Re: **Marysville Corporate Center BSP**  
*Final Review 2 PA22004*  
Project Number 2200444.06

In response to your plan review checklist dated April 6, 2024, we have addressed the items below, with our responses following your comments.

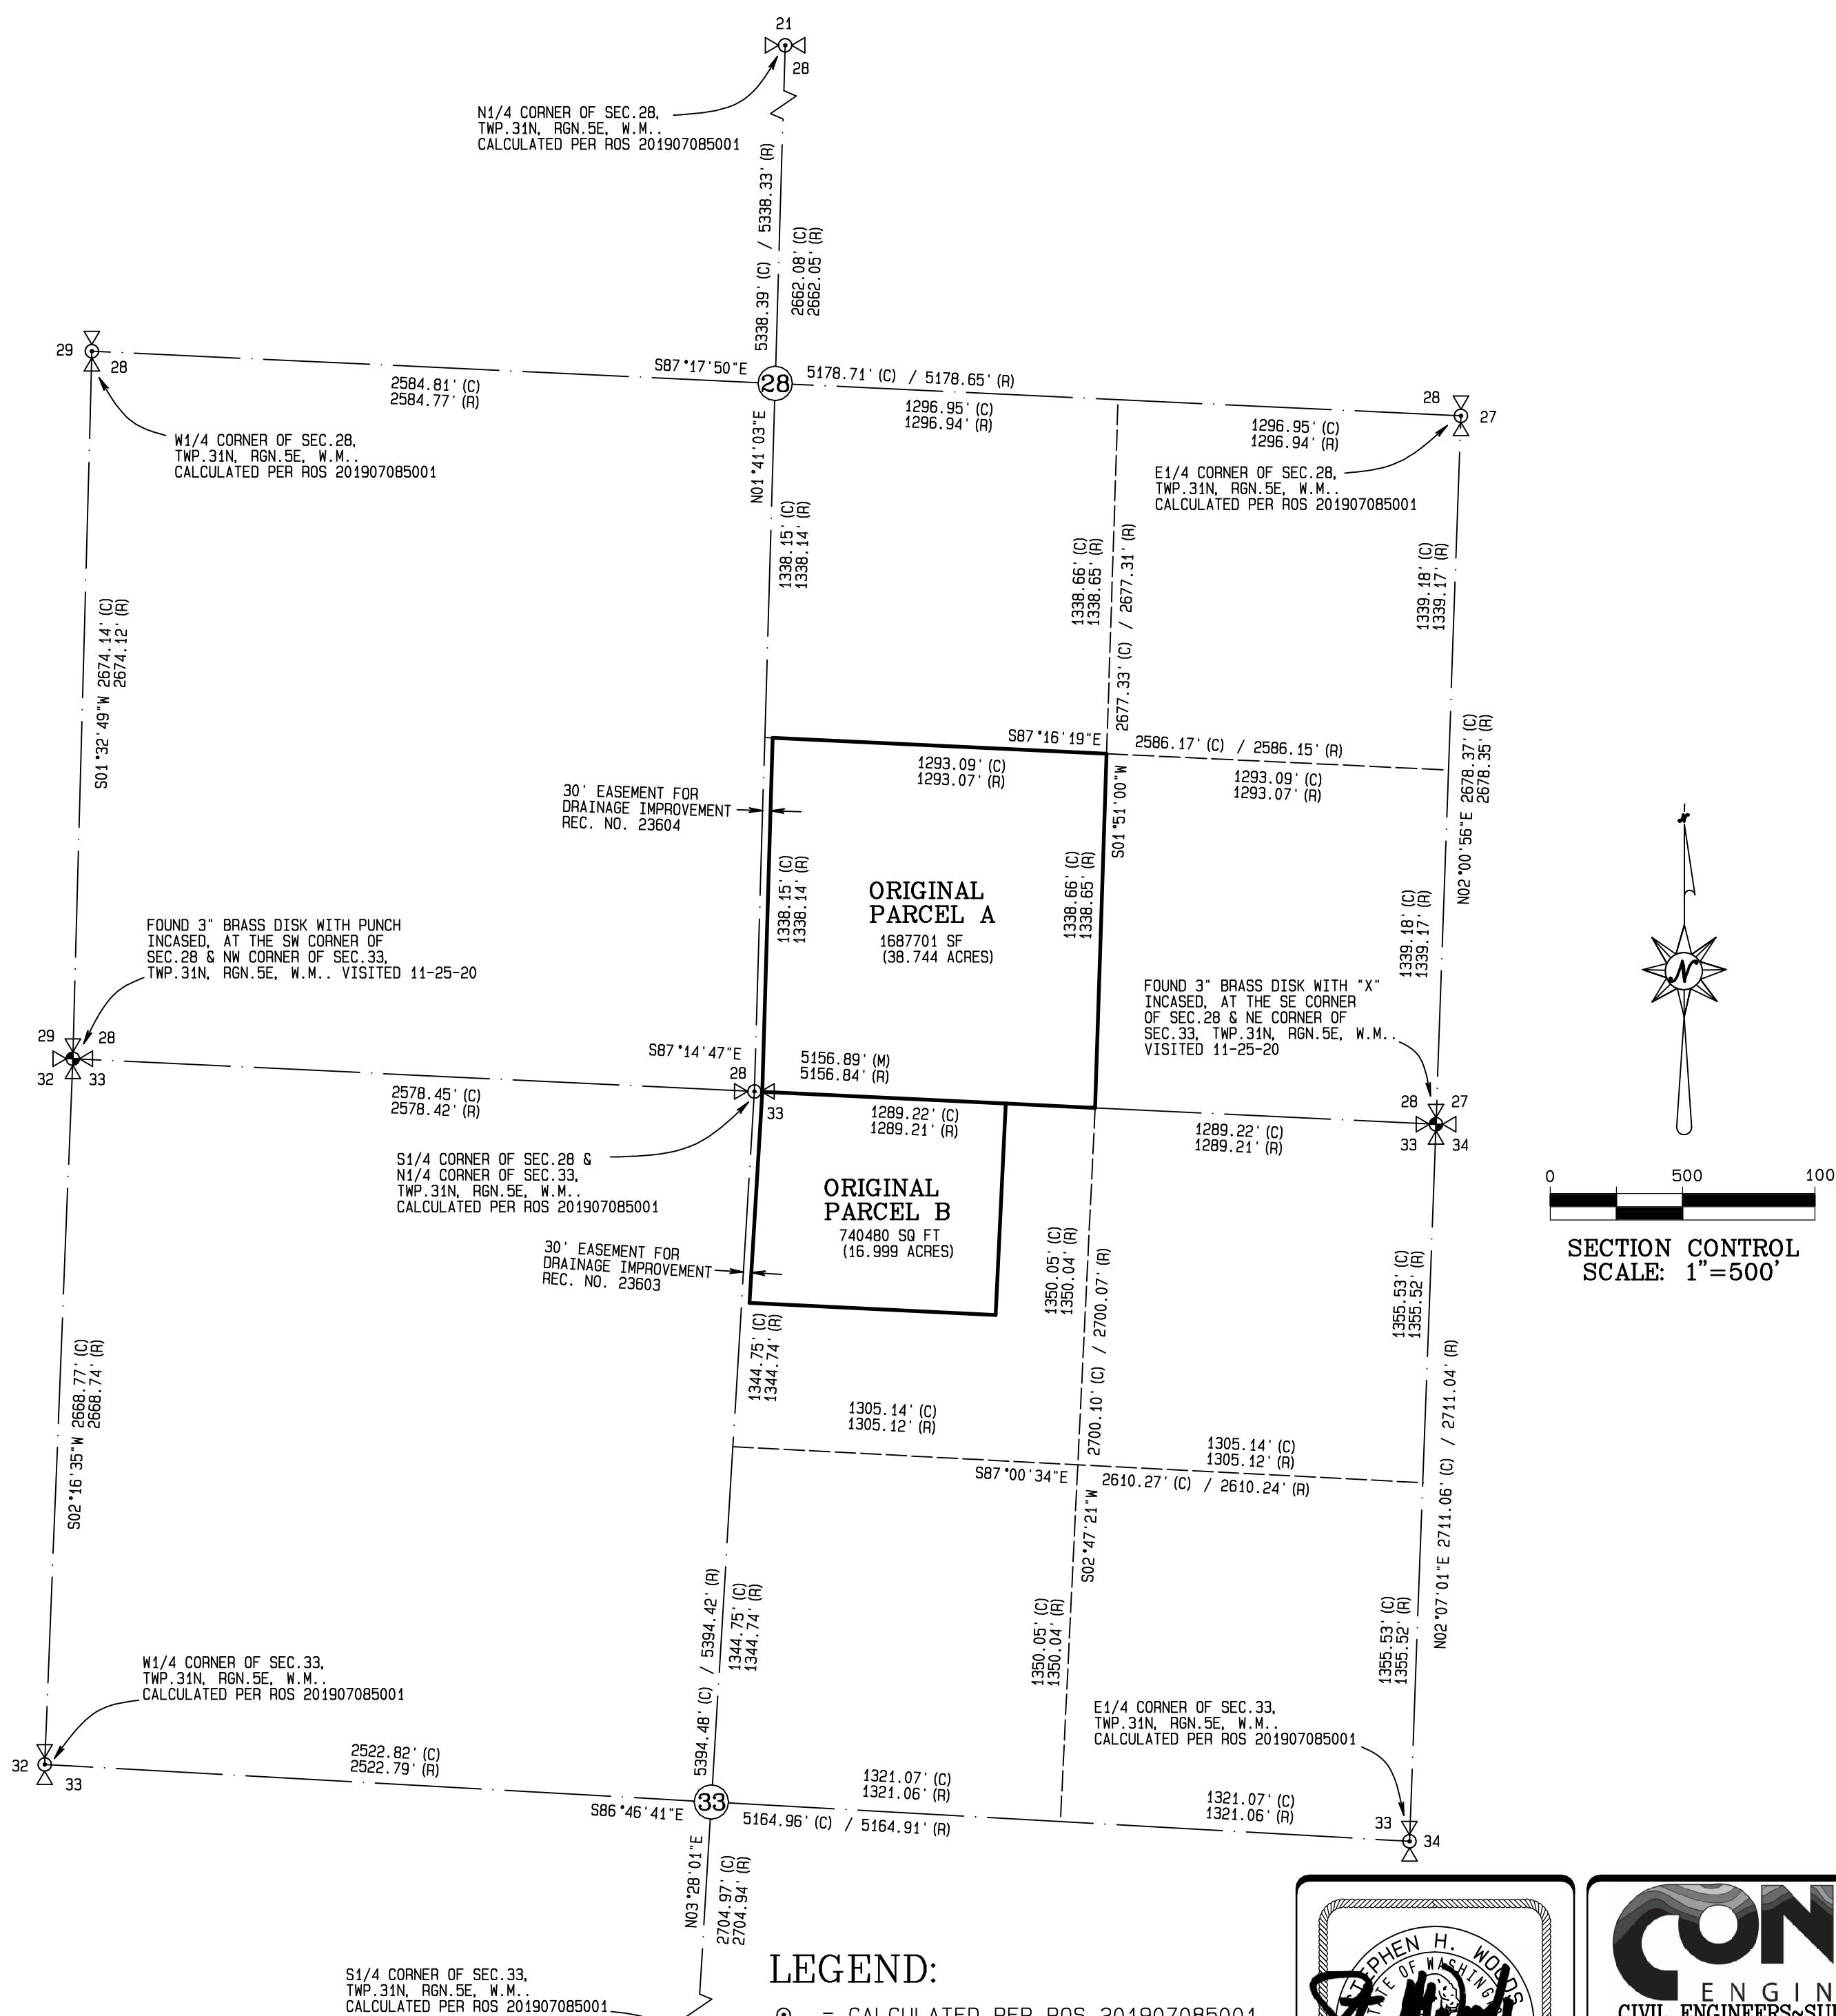
2. *Sheet 2 of 9: TITLE REPORT ITEM NOTES No. 10, Add AFN 202402010260*

**Response:** AFN added to revised final BSP.

SHEET 6 OF 9

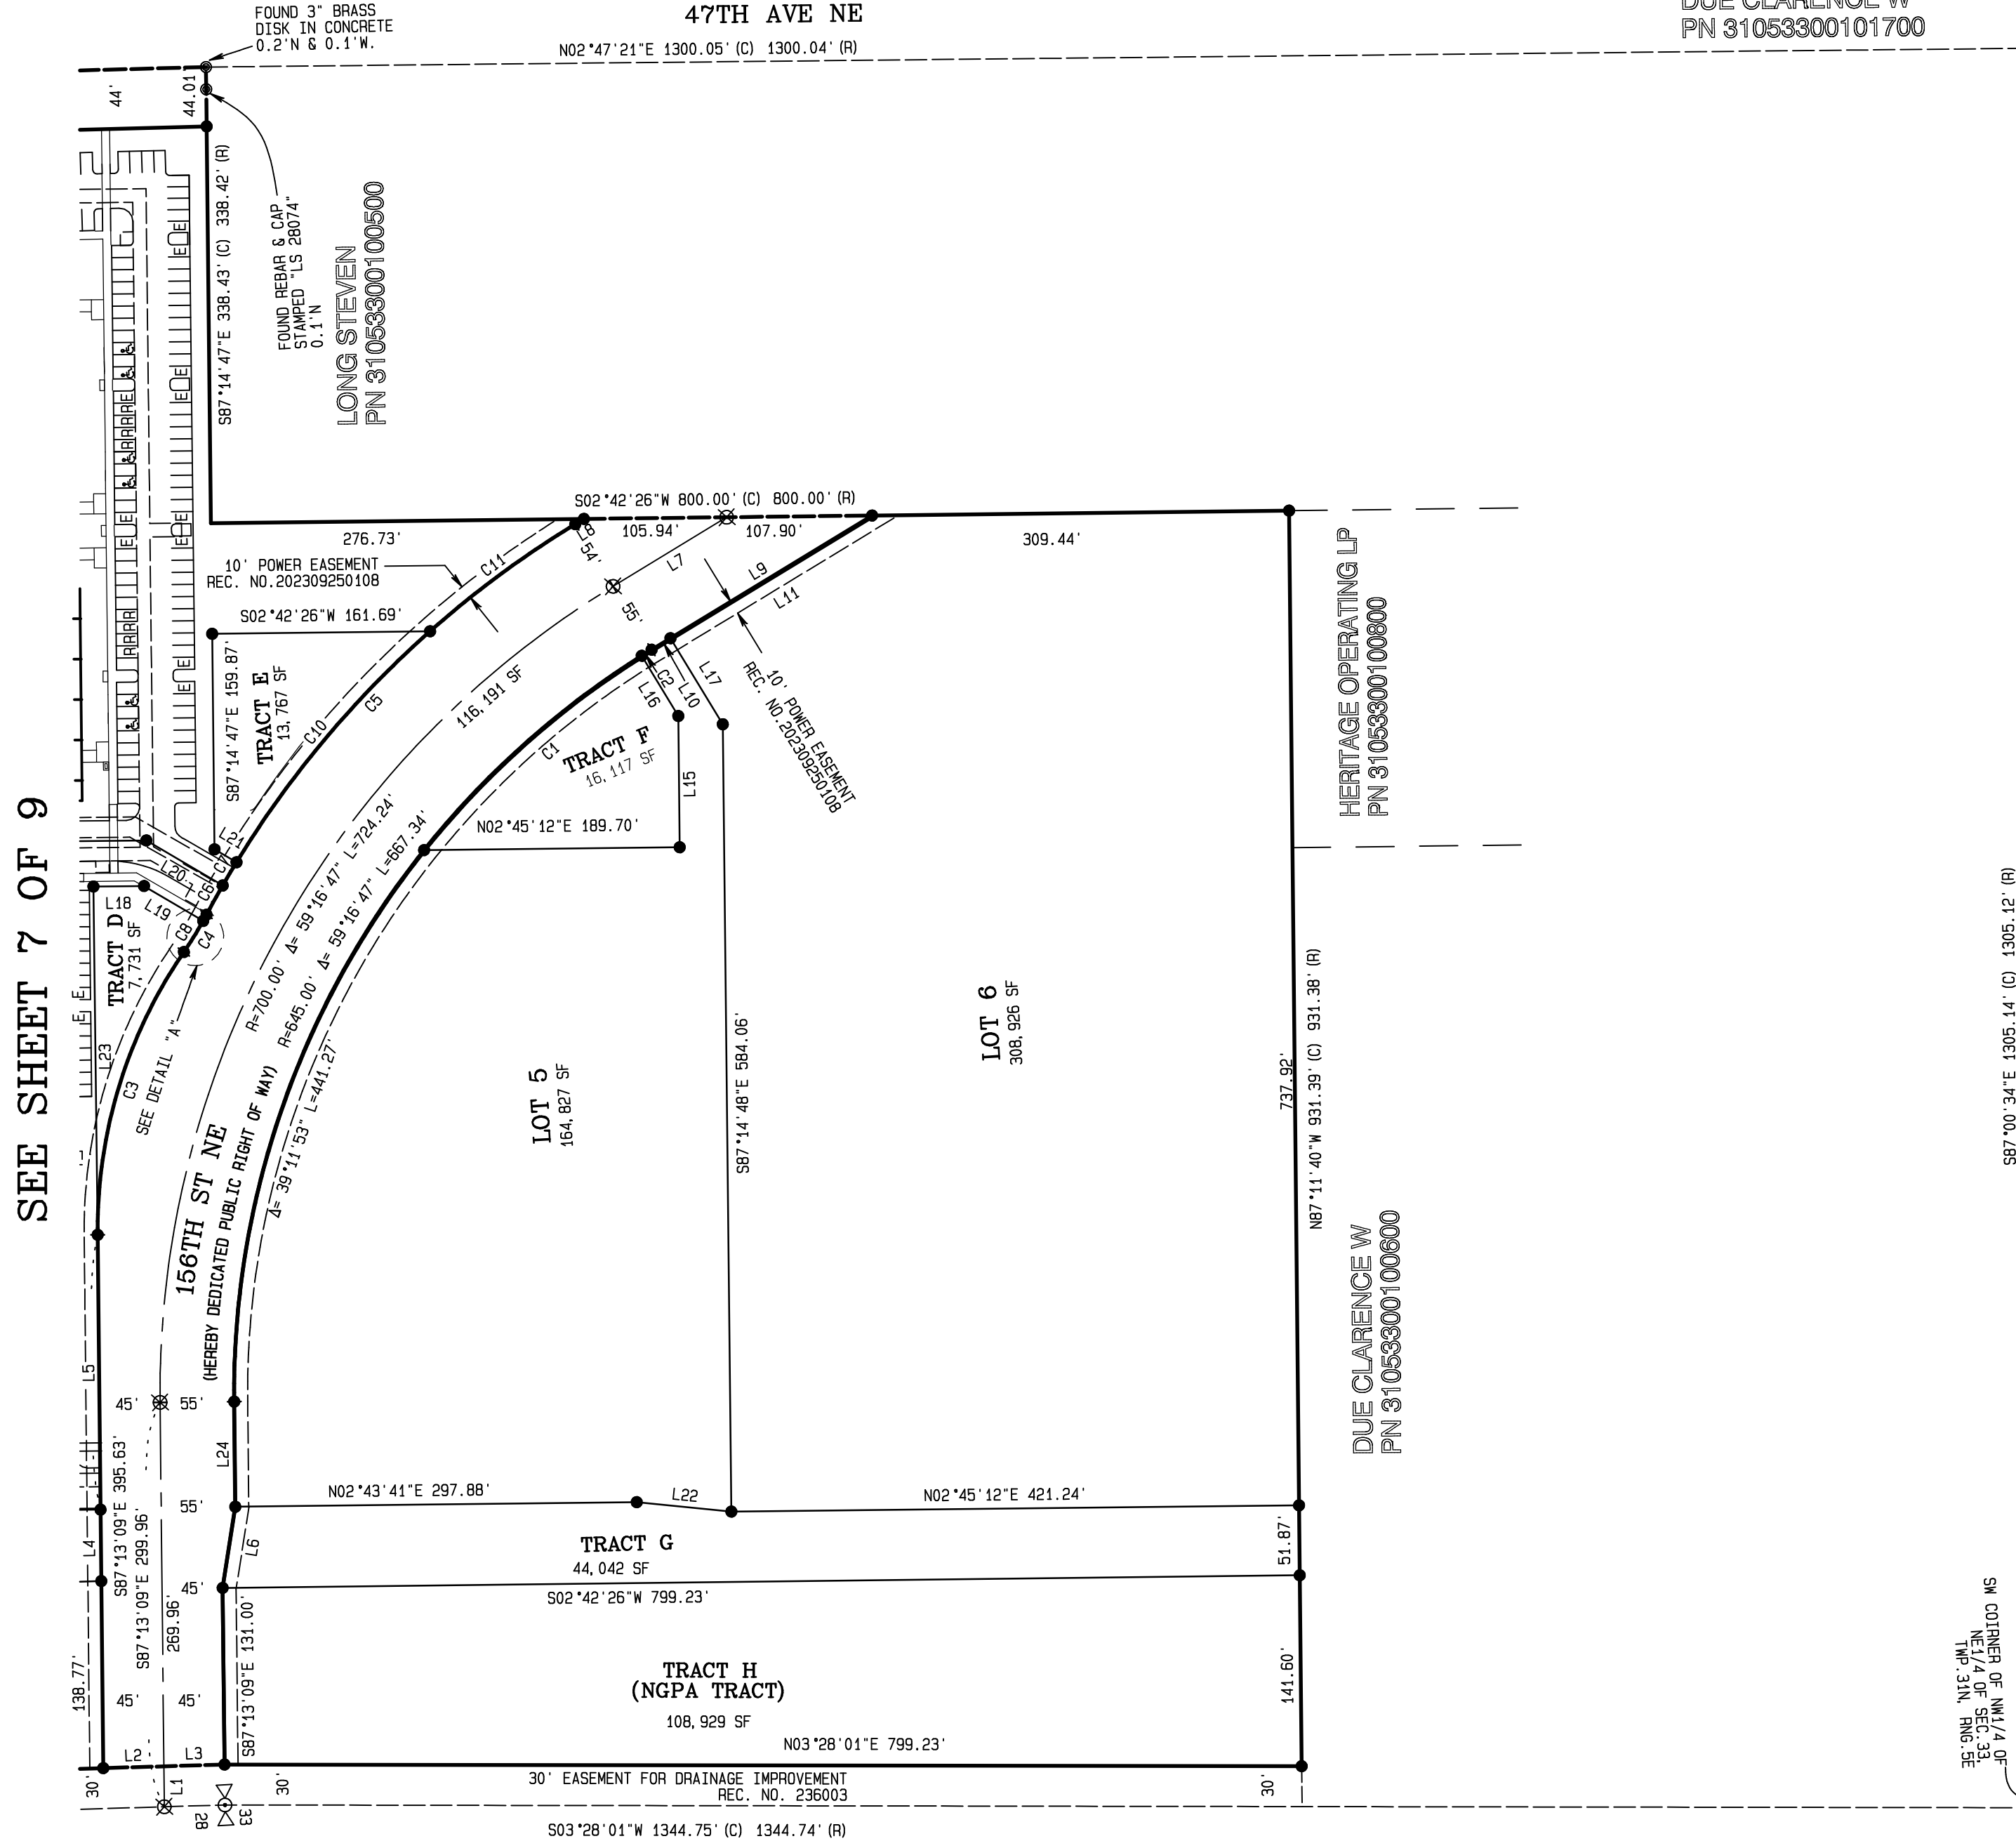
3. *Sheet 6 of 9: Remove CARPOOL PARKING SIGN exhibit and language.*

**Response:** Carpool parking sign exhibit and language have been removed.

INDEX DATA: SEC 28-33 T 31N R 5E WM
SURVEY FOR: PACIFIC REALTY ASSOCIATES, L.P. 15908 47TH AVE NE MARYSVILLE, WA 98271
SNOHOMISH COUNTY, WASHINGTON
SHEET 7 OF 9

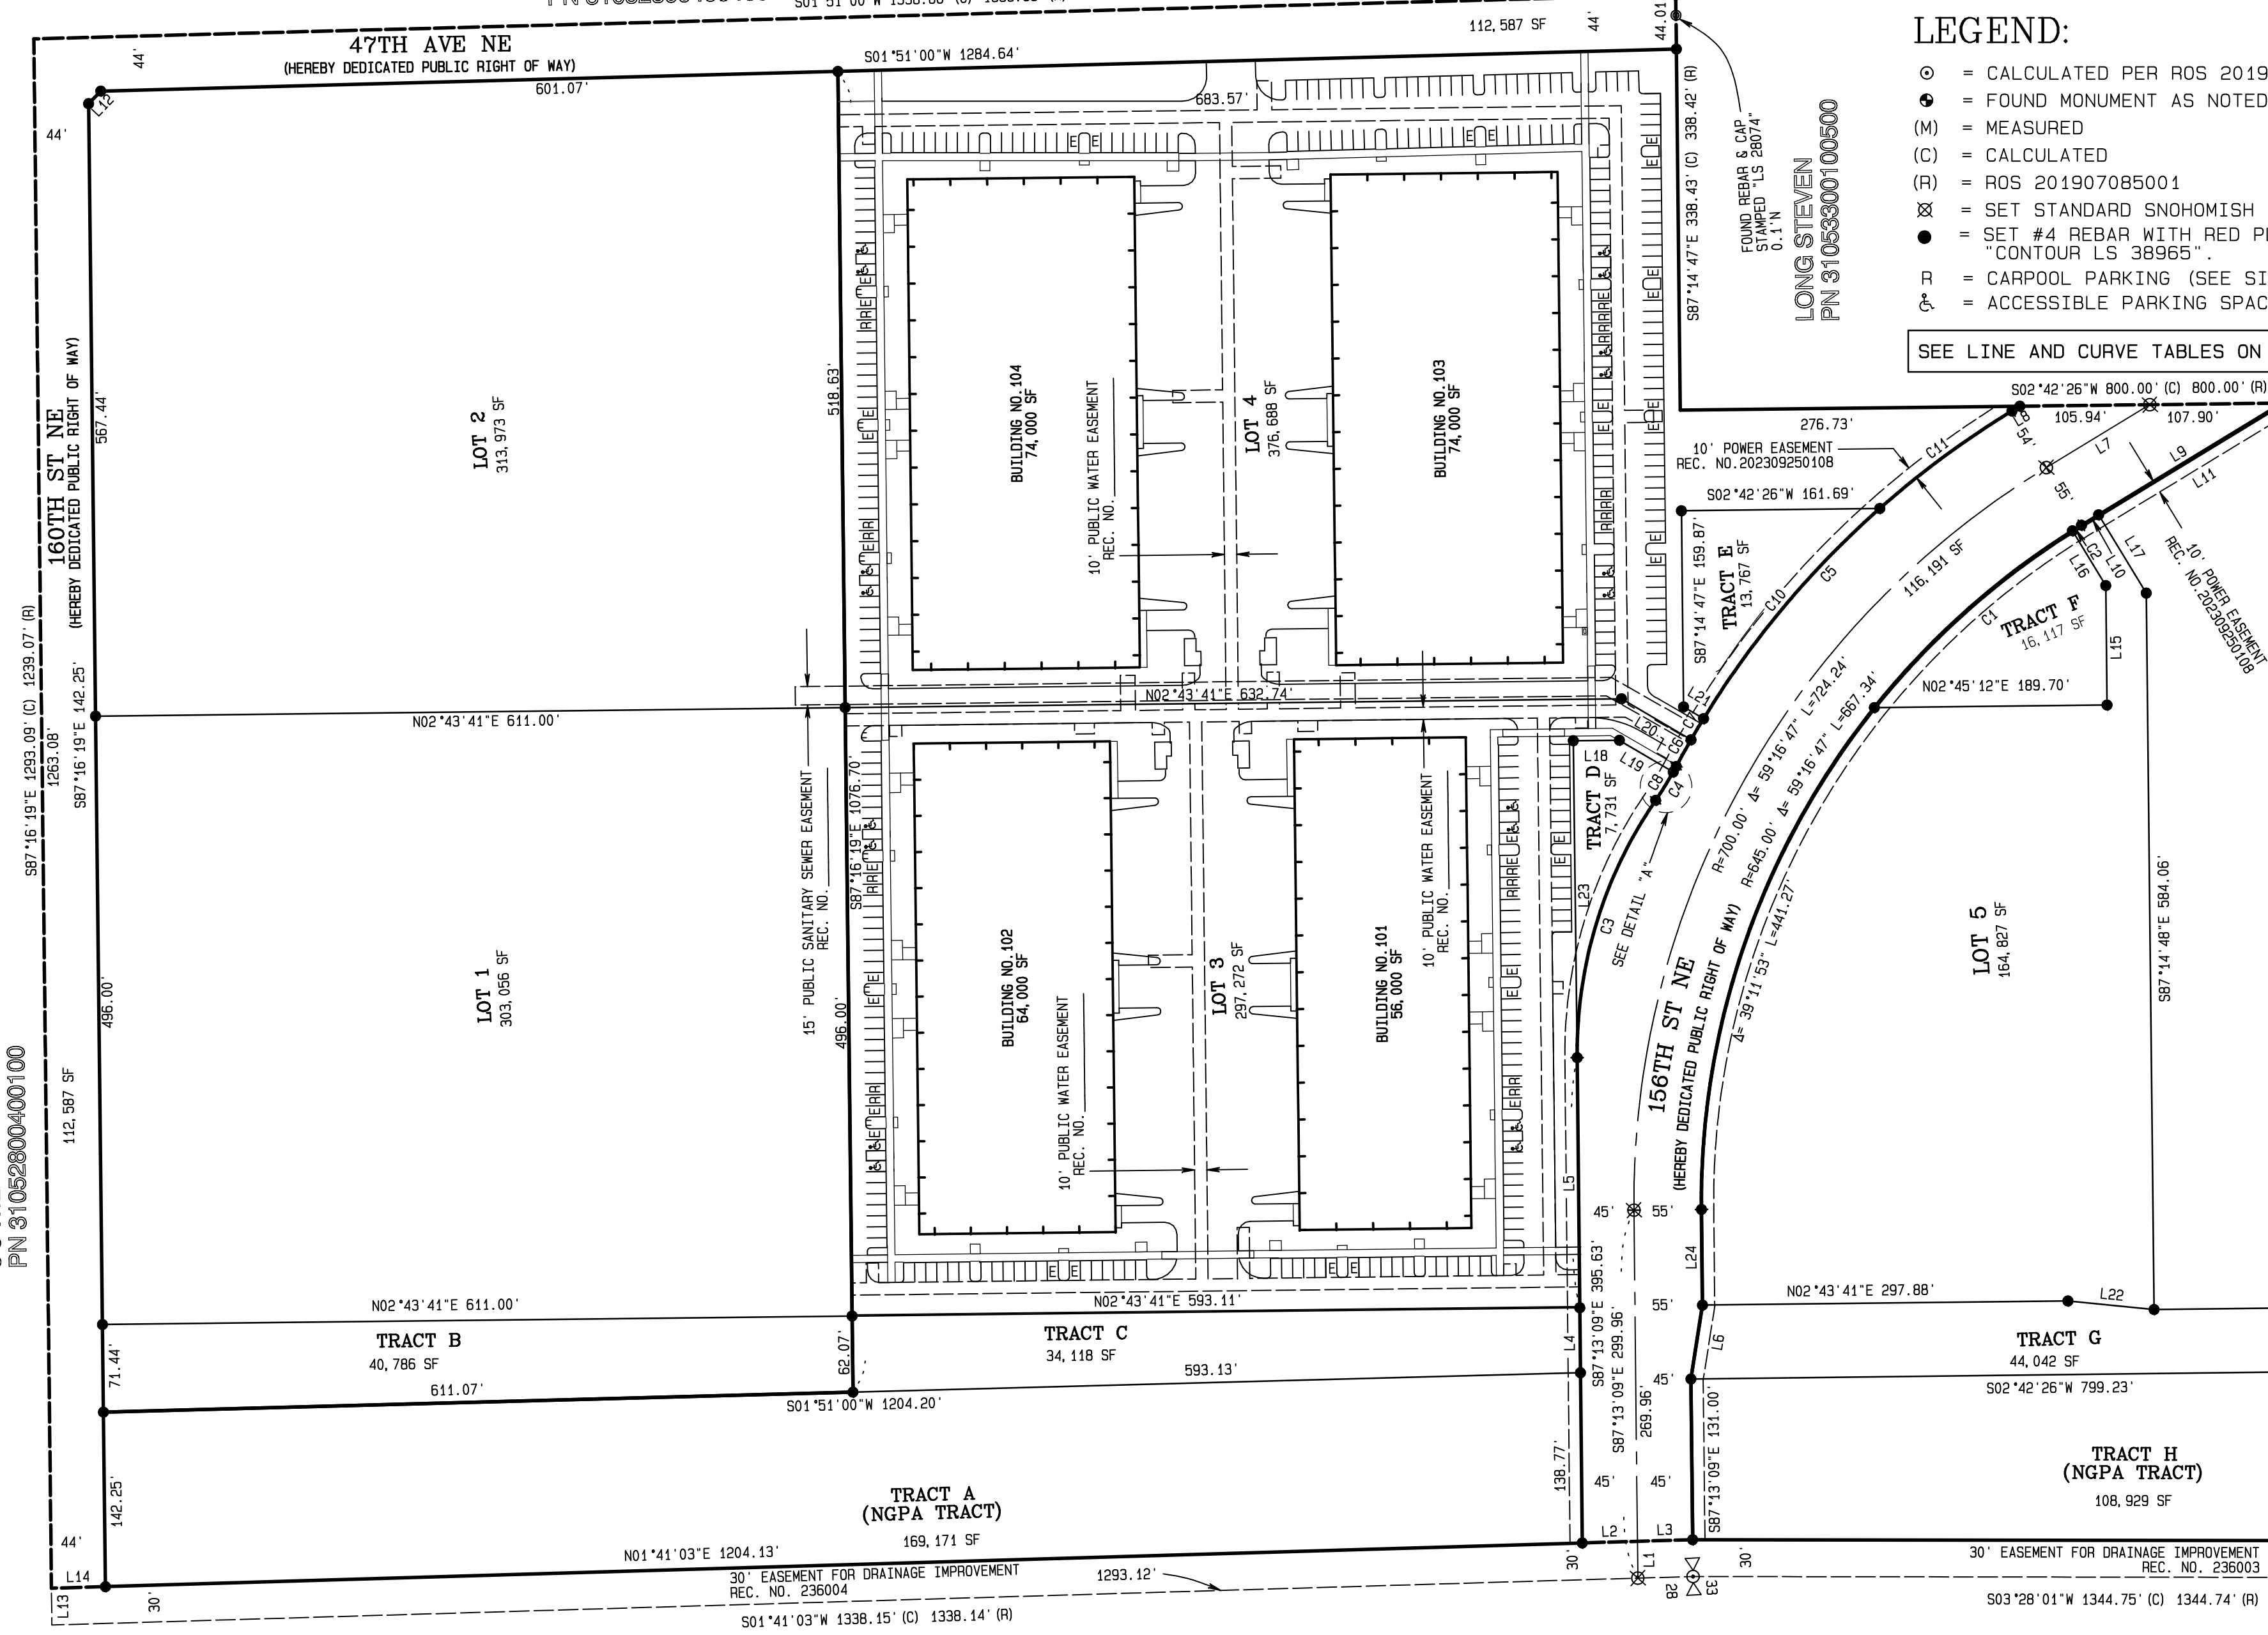
4. *Sheet 7 of 9: Remove the swale from Lot 4. Only the lot lines should be shown.*

**Response:** Swale on lot 4 has been removed from the final BSP.
